From: Martin Hill <Martin.Hill@arun.gov.uk>
Sent: 18 February 2022 17:01
To: Planning.Responses <Planning.Responses@arun.gov.uk>
Subject: RE: Planning Consultation on: LU/5/22/PL

Comments from Private Sector Housing:

Application No: LU/5/22/PL
Registered: 15th February 2022
Site Address: 37 Griffin Crescent Littlehampton BN17 7LH
Grid Reference: 502912 103775
Description of Works: Change of use from a single dwelling into two flats and rear two storey extension and rear dormer. This application is in CIL Zone 2 (Zero Rated) as flats.

DRWG No: **1049_201**

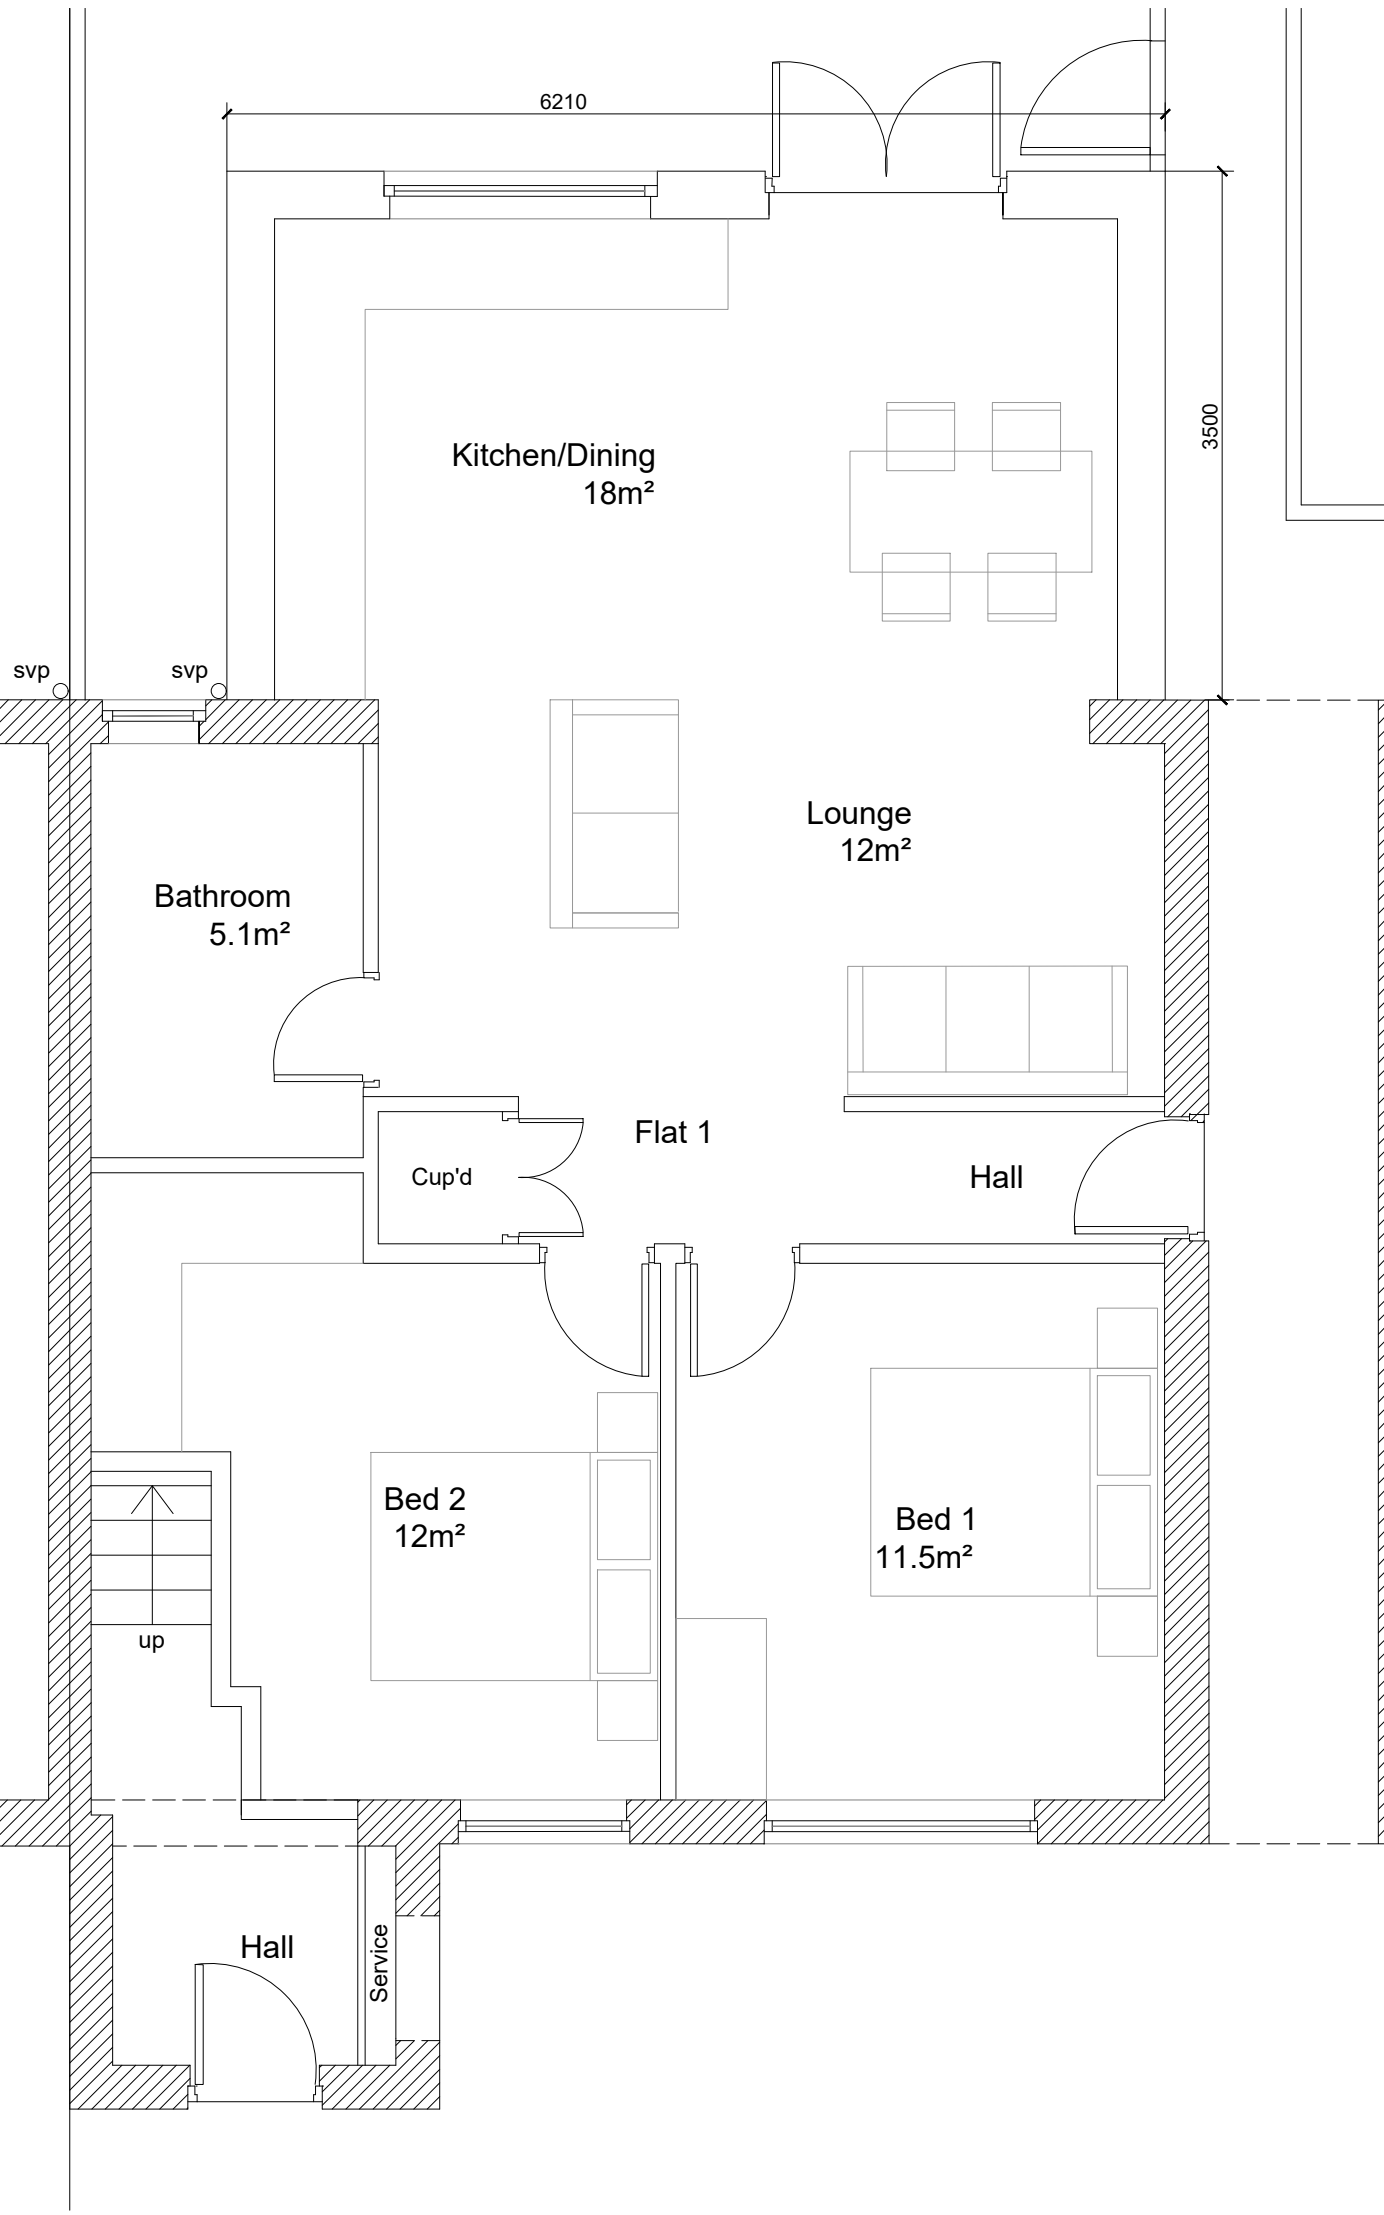
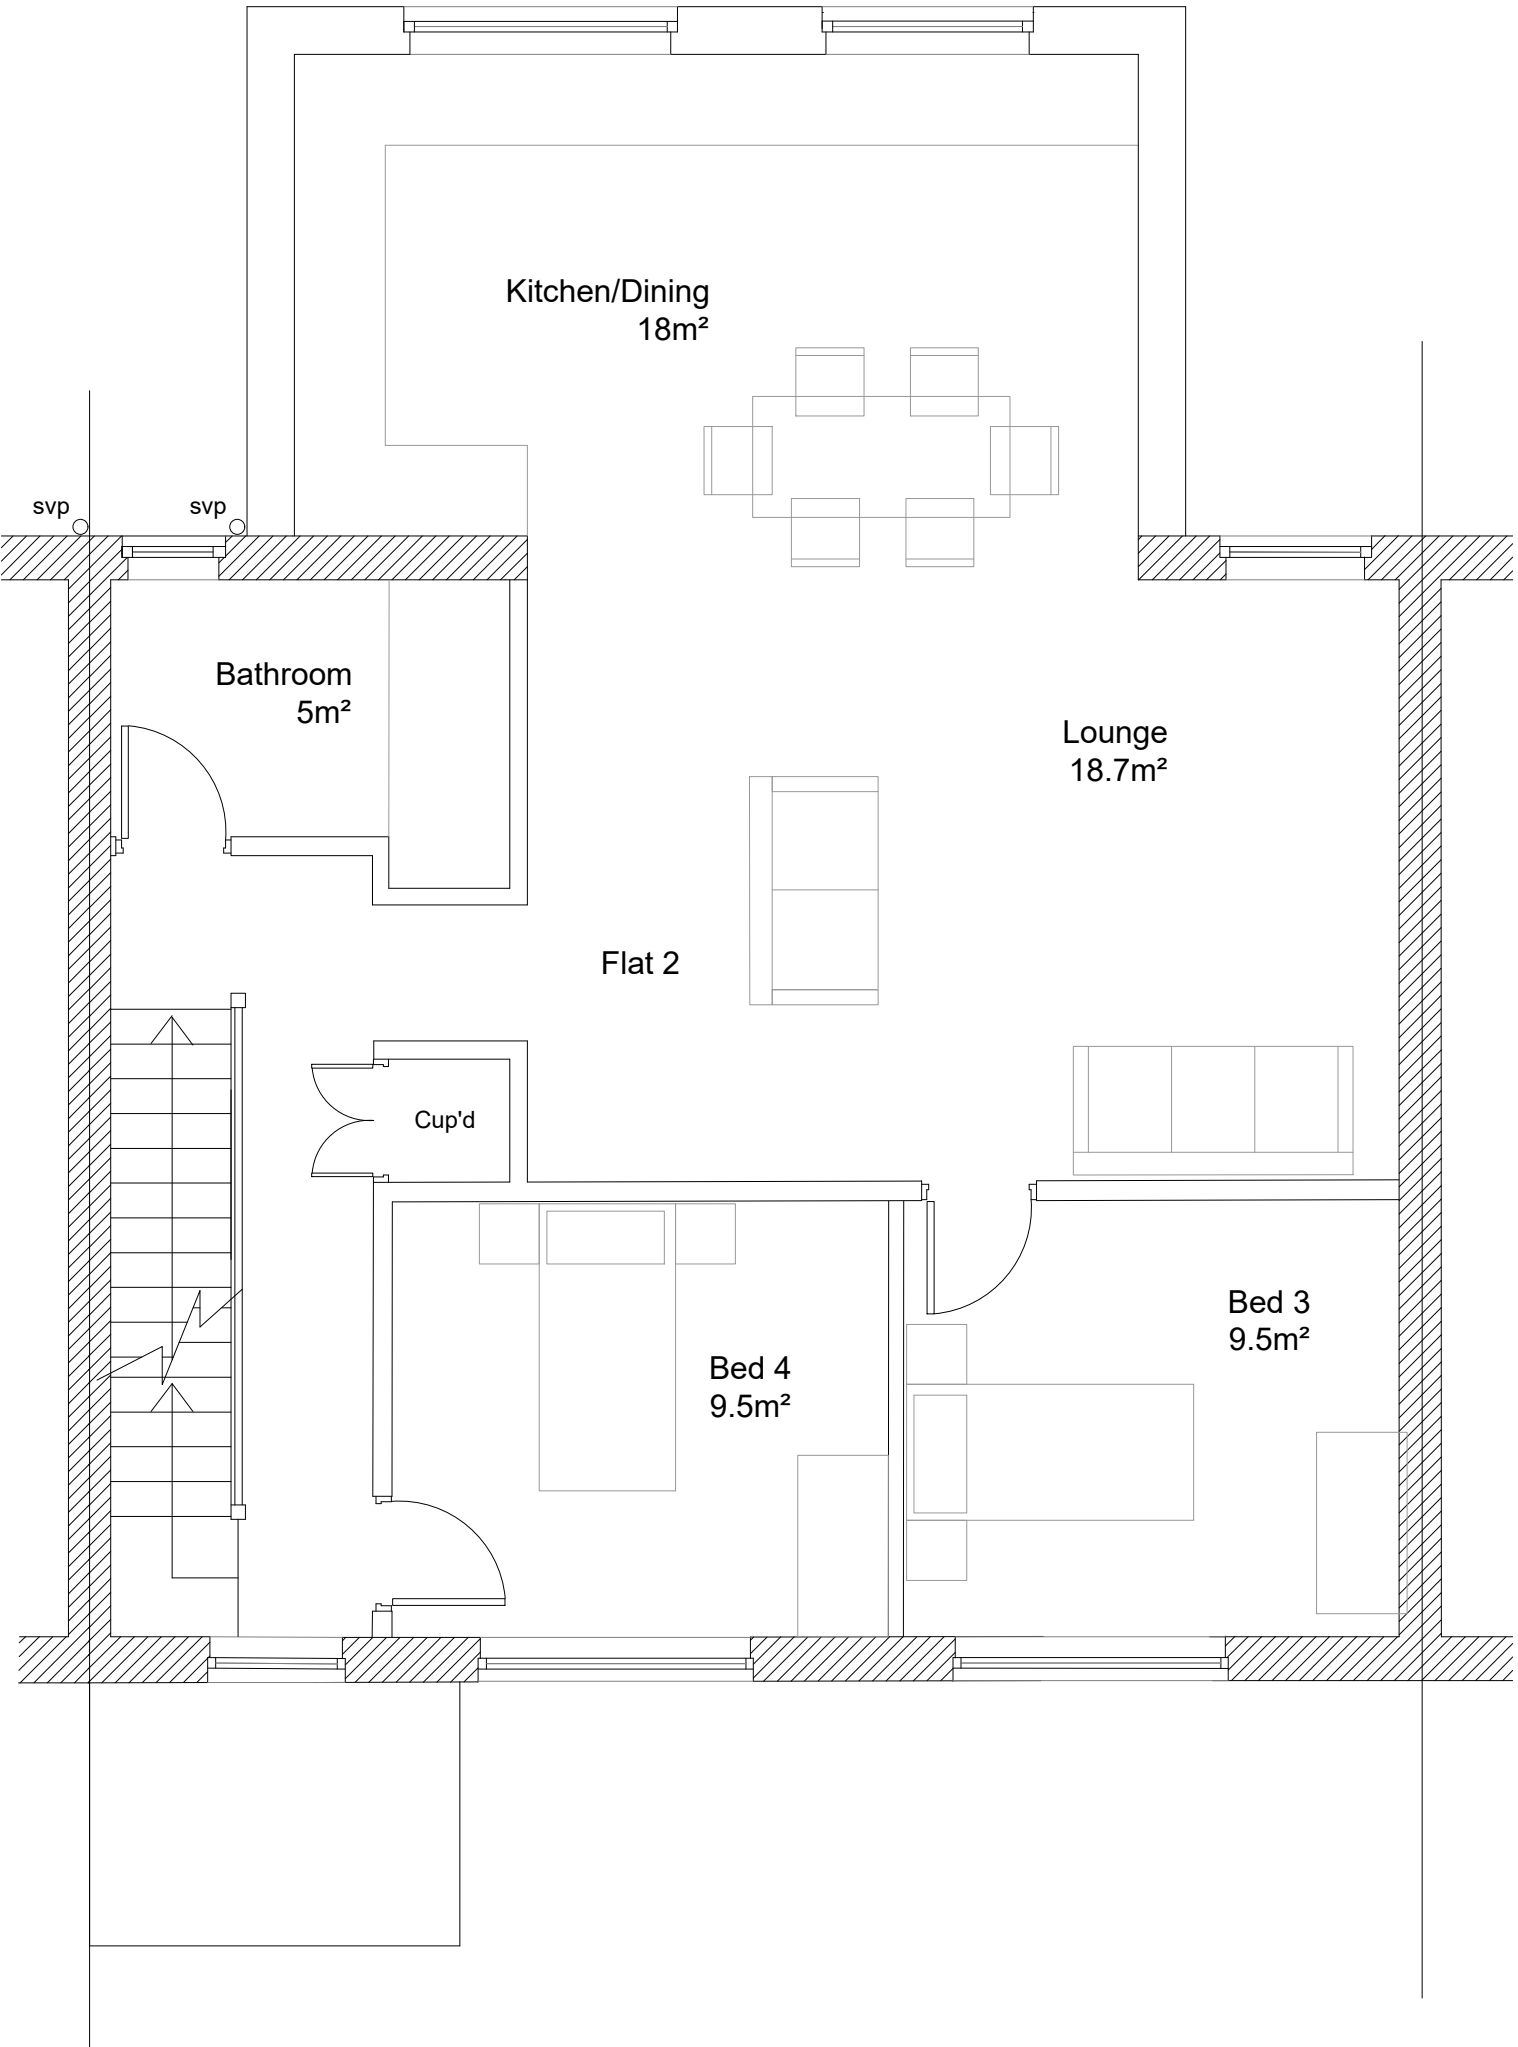
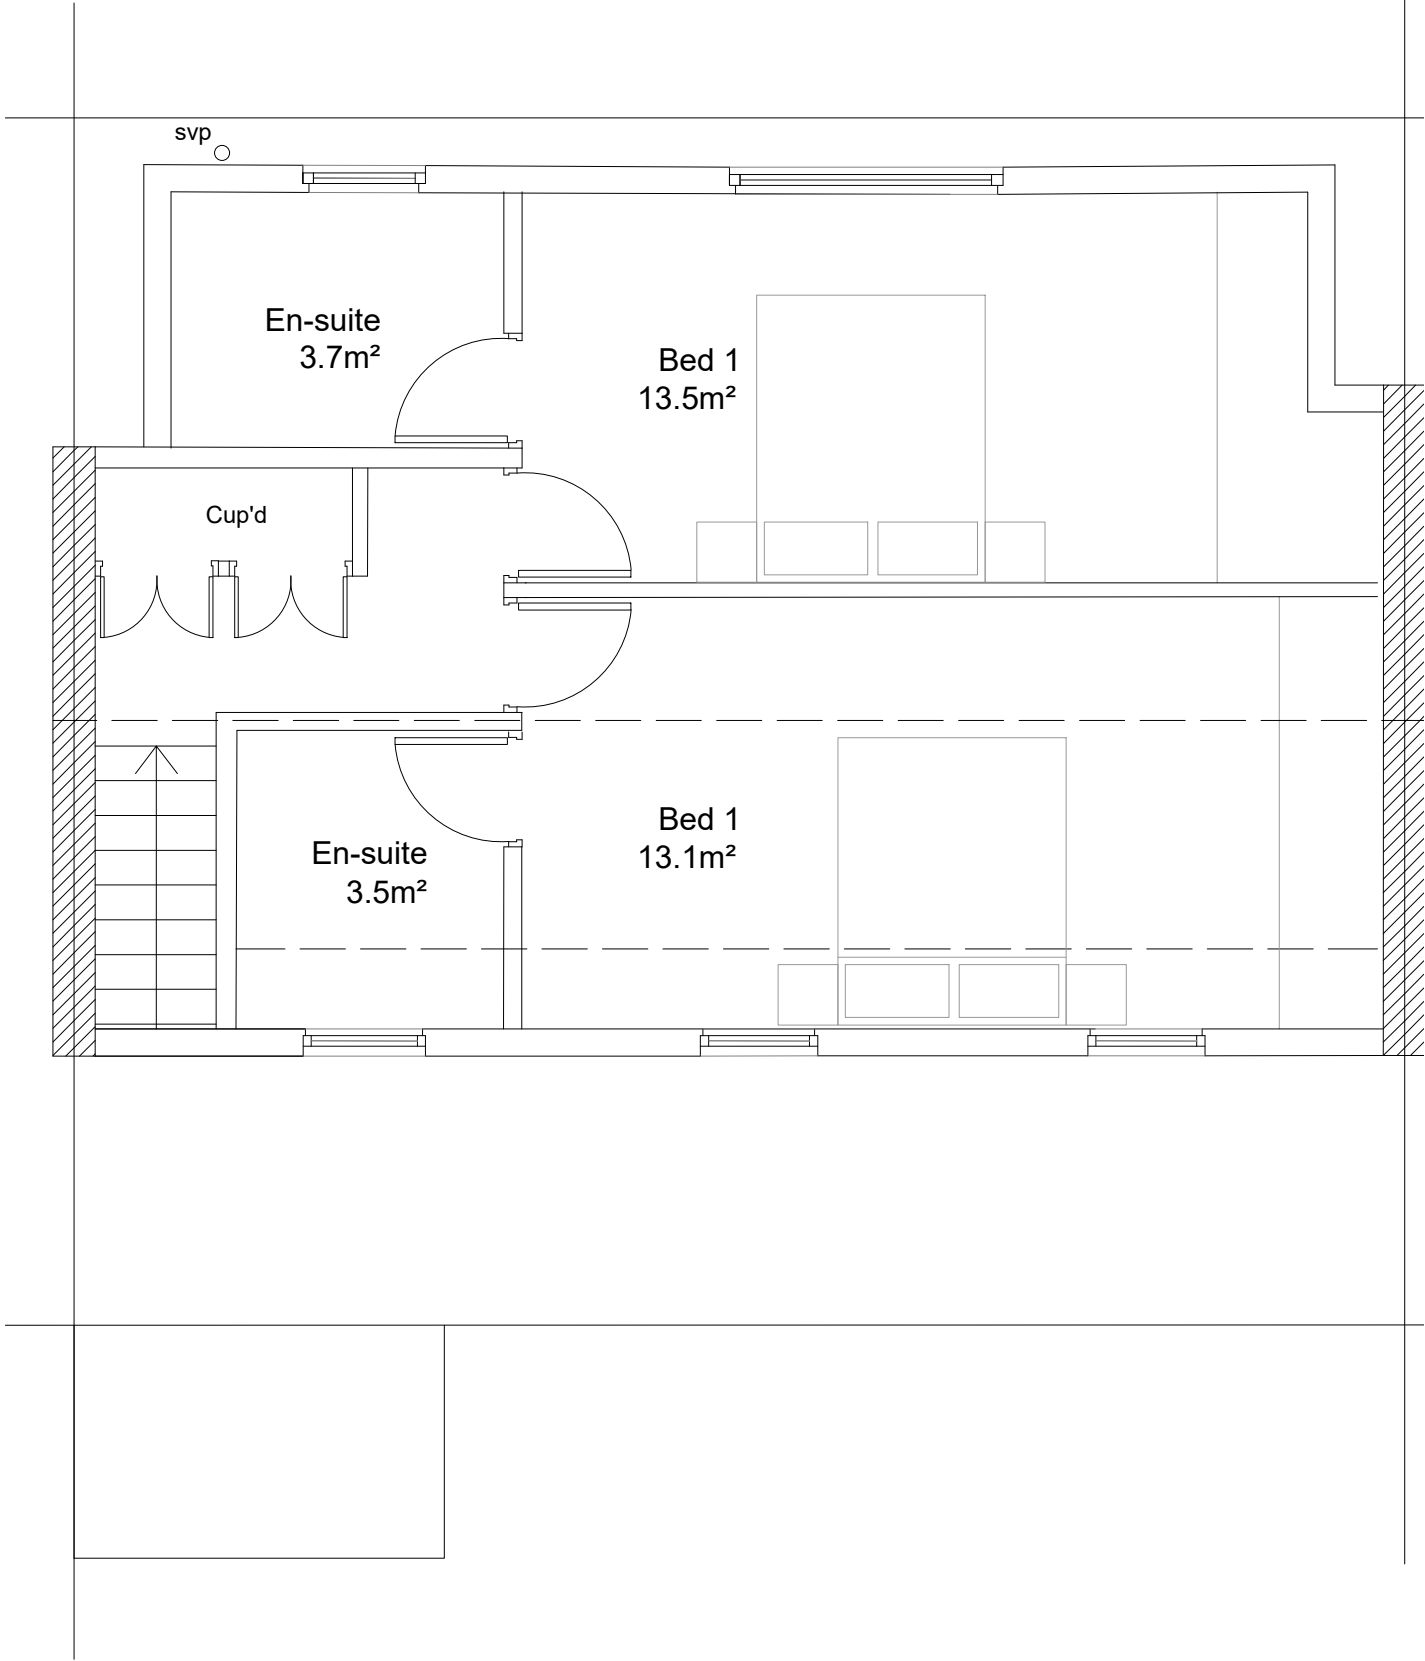
- A room where the only escape route is through another room is termed an “inner room” and poses a risk to its occupiers if a fire starts unnoticed in the outer room. The escape routes from bedrooms in the ground floor flat and the bedrooms in the upper flat are via kitchen/diner/lounges. The ideal solution to overcome this is by separating the kitchen/dining/lounge areas from the rest of each dwelling with a partition wall and access door. This will allow each bedroom to then open directly onto an escape route, without entering a high risk, outer room. An alternative to this may be to install an escape window in each bedroom (not more than 4.5 metres above ground level), installing additional interlinked smoke detection in the outer room and by installing a minimum FD30S standard

fire door to each bedroom. An escape window is not acceptable above 4.5m above ground level.

- There must be a minimum of a close-fitting conventional door installed to separate the first floor kitchen/diner/lounge from the escape staircase if the kitchen/diner/ lounge is not to be separated as suggested above by way of a partition wall and access door; the staircase must be protected with compartmentation and not open to risk areas which may compromise the means of escape in the event of a fire occurring.

- Cupboards containing services such as mains electrics should be enclosed in a fire resisting enclosure to protect the means of escape.
- Minimum 30 minutes fire resistance between each flat (horizontally and vertically)

- Install thumb turn opening devices to each final exit door.
- In accordance with LACoRS fire safety guidance for a 3 storey building converted into self-contained flats, a Grade A, LD2 fire alarm and detection system is required:

- o Interlinked smoke detection in any common areas.
 - o Interlinked heat alarms to be located in the entrance lobby of each flat

- o A Grade D LD3 fire alarm and detection system of interlinked smoke detection with integral battery back-up installed on each storey within each flat
- o It is recommended to install interlinked heat detection with integral battery back-up (Grade D) in the kitchen of each flat also.

Consultation must be sought from West Sussex Fire & Rescue Service and Building Control in order to establish the most appropriate fire alarm and detection system for this property because these plans do not appear to directly align with the guidance examples, as detailed in LACoRS.
